Subject: The George Hotel- amended plans

Amended plans have been submitted that show retention of the floor structure and ceiling above the first-floor conference room (Commercial Room) and retention of the section of the ground floor that is above the barrel arches in the basement. We have not been officially re-consulted but offer the following comments to assist the Planning Committee in considering the application.

Proposed Reflected Ceiling Plan
1:50

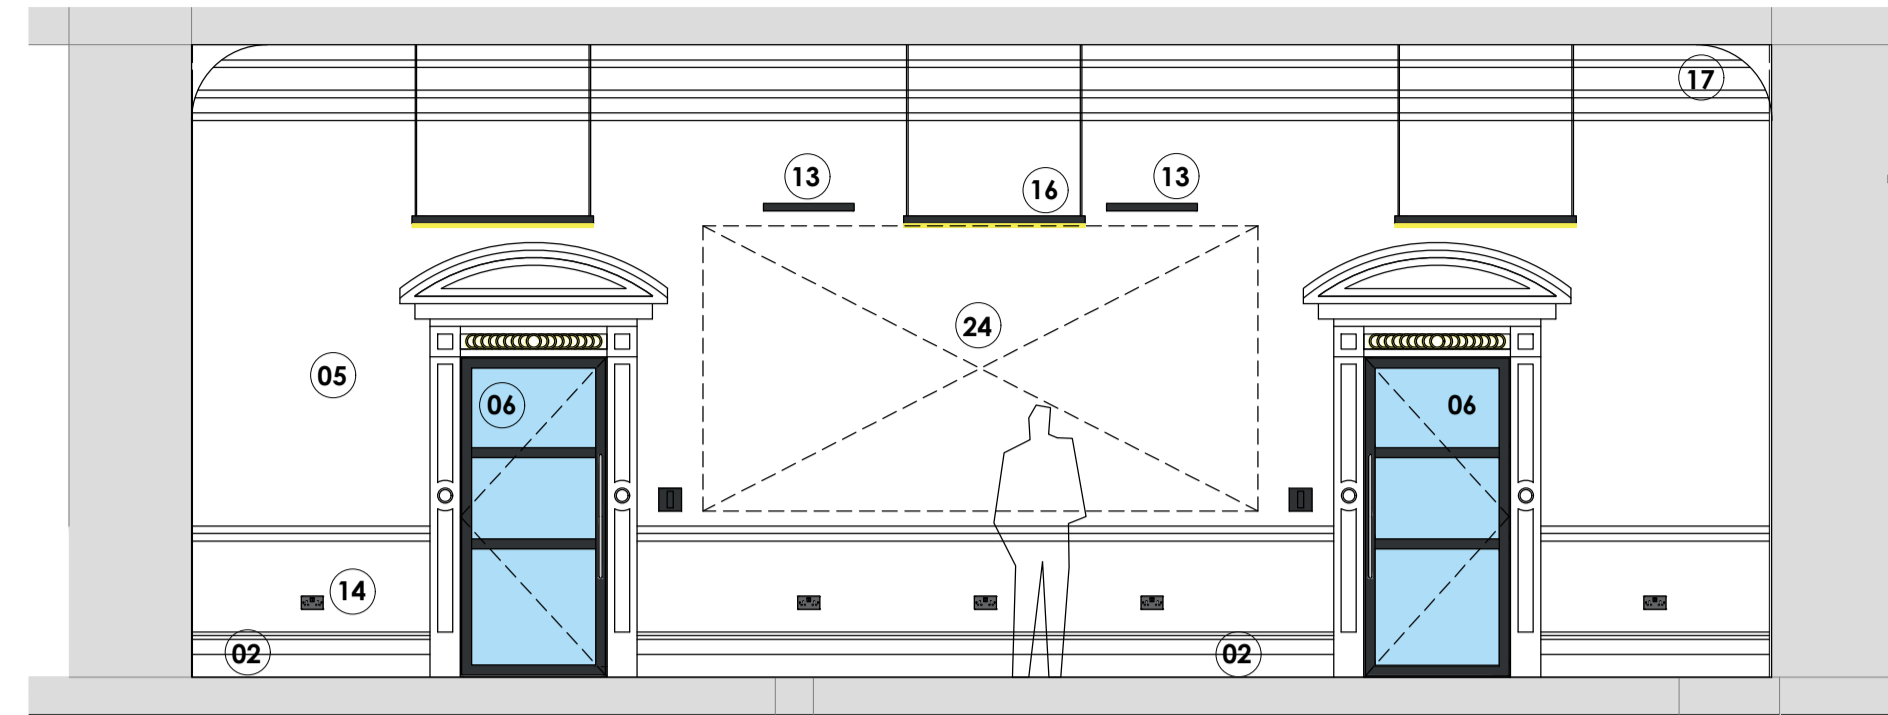
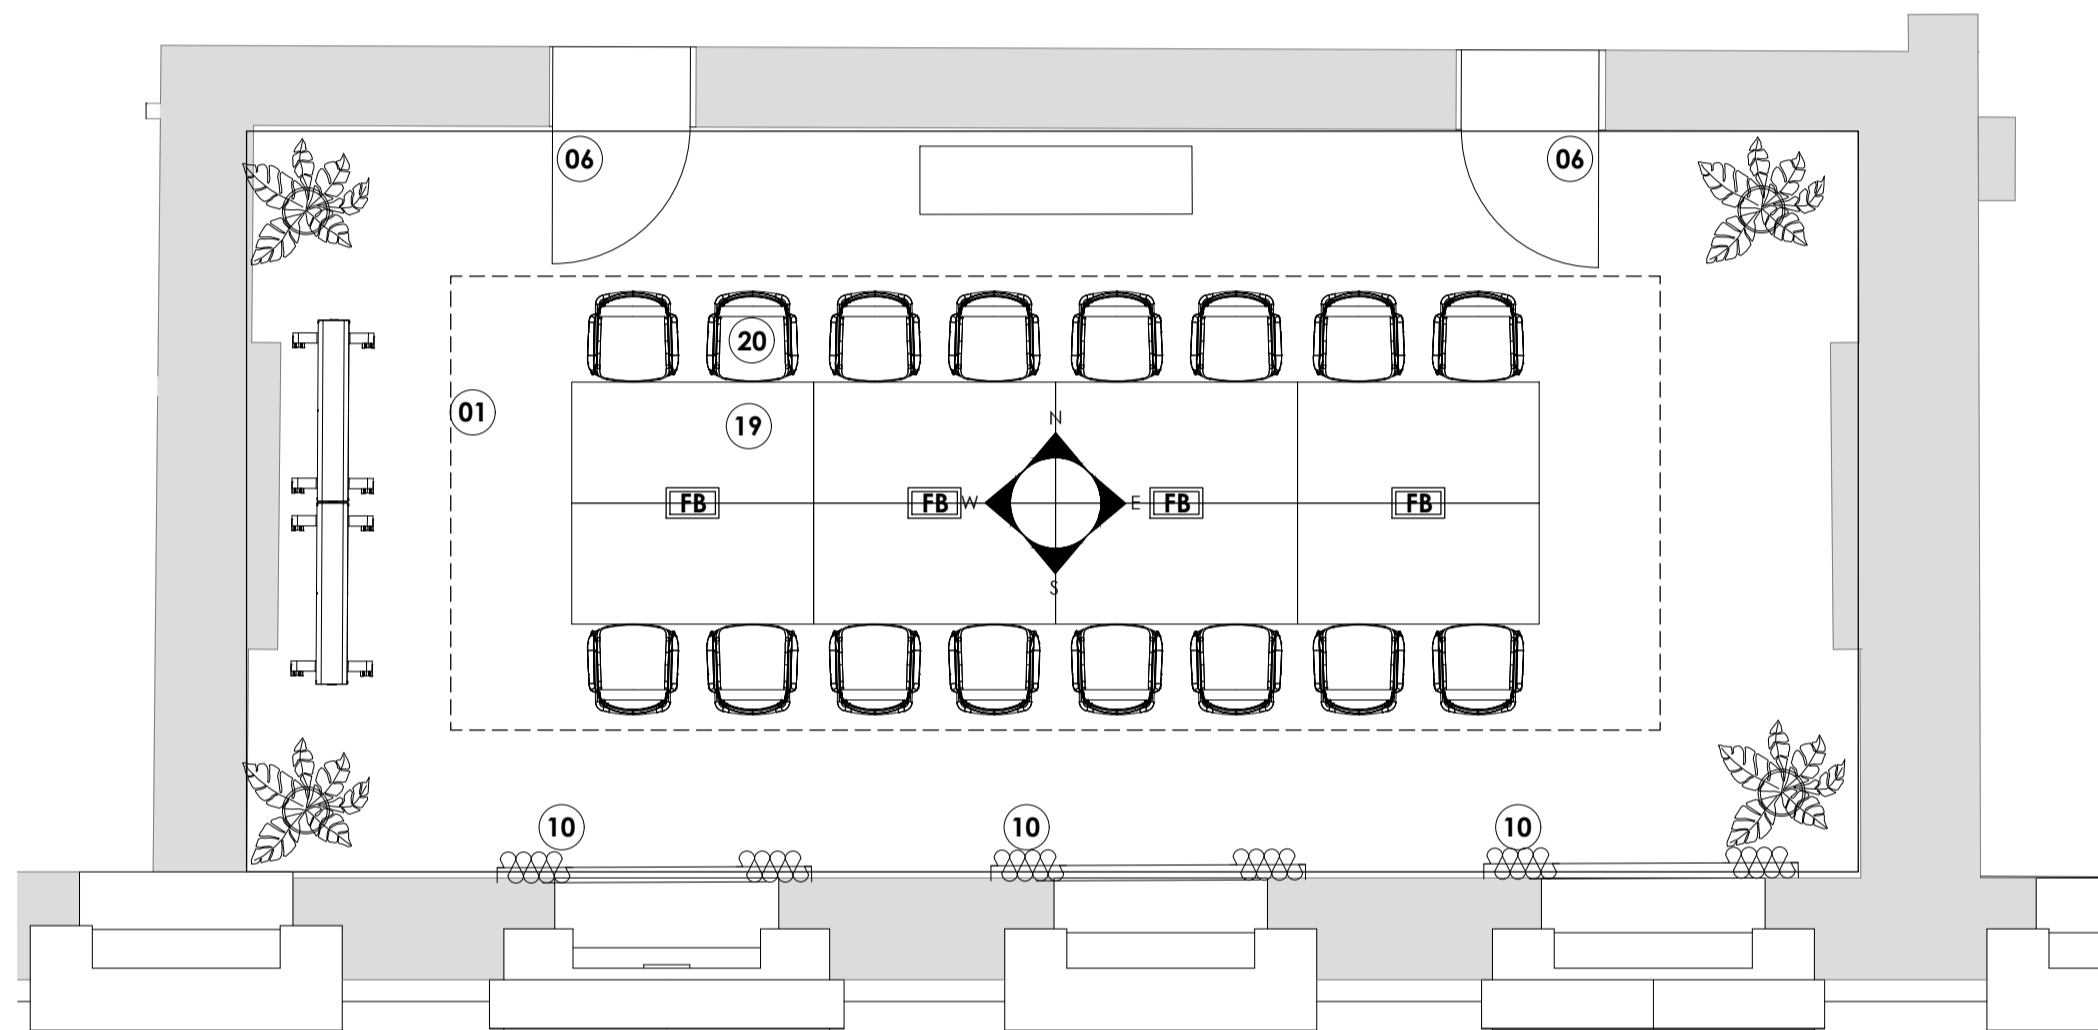
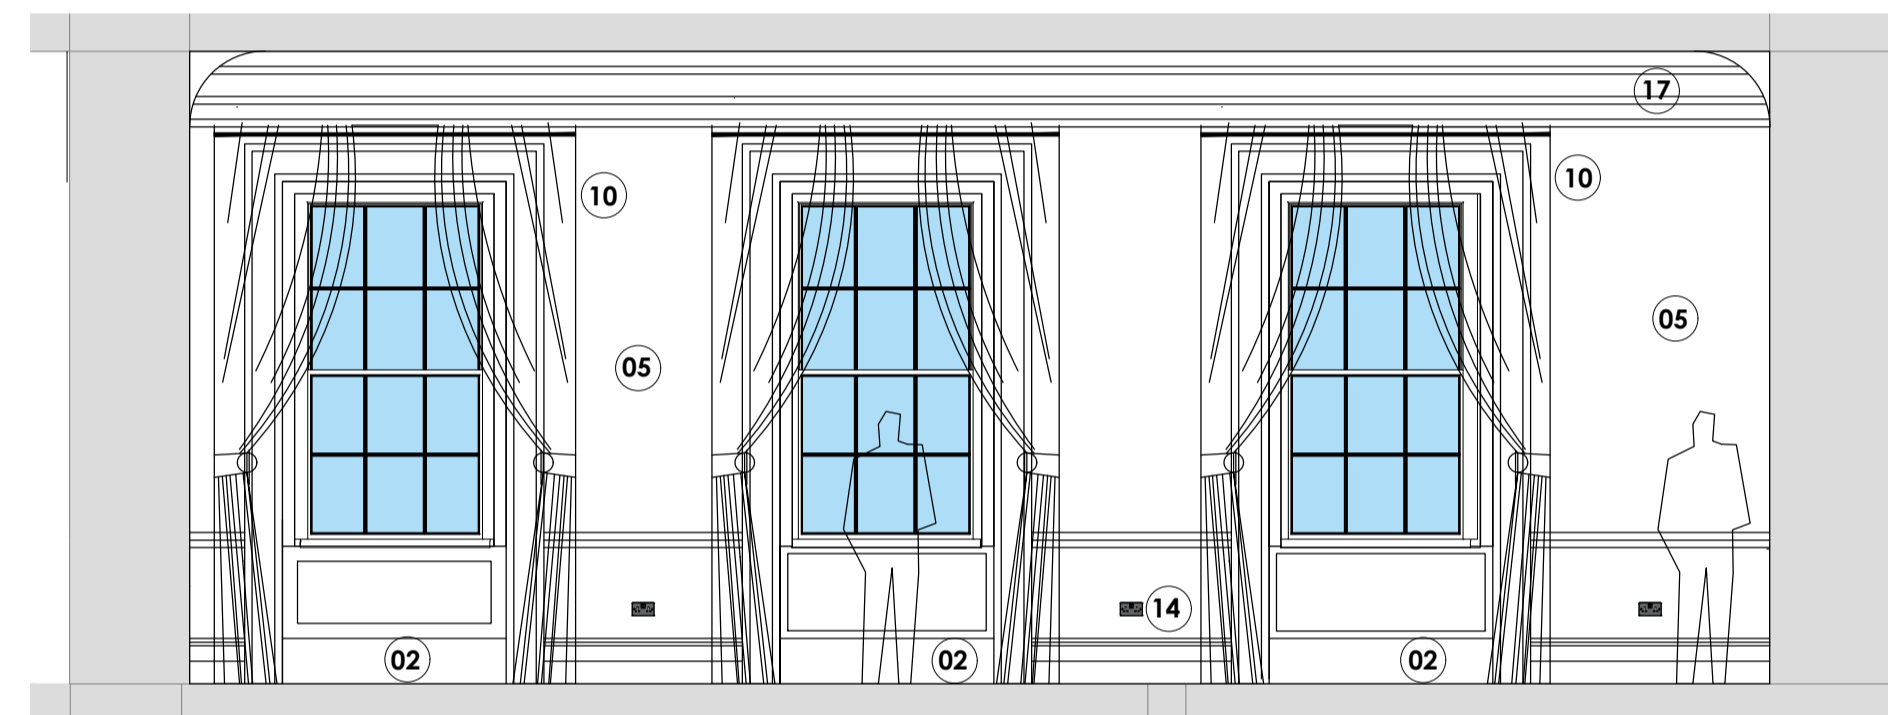
It continues to be our position that this is the best conservation solution for this space, given its significance. The Commercial Room is one of the principal rooms that contributes a great deal to the significance of The George. It is a Grade II* listed building which means every effort should be

made to retain any elements that contribute to its significance. We have concerns about the impact of both the loss of fabric and the changes to the architectural composition/ proportions of the room through lowering the ceiling.

It therefore remains our position that a bespoke solution is required for the ceiling above the Commercial Room and the area of the ground floor above the barrel arches in the basement. We welcome the amended plans which indicate this sensitive solution and address the concerns outlined in our letter of 9 May 2023.
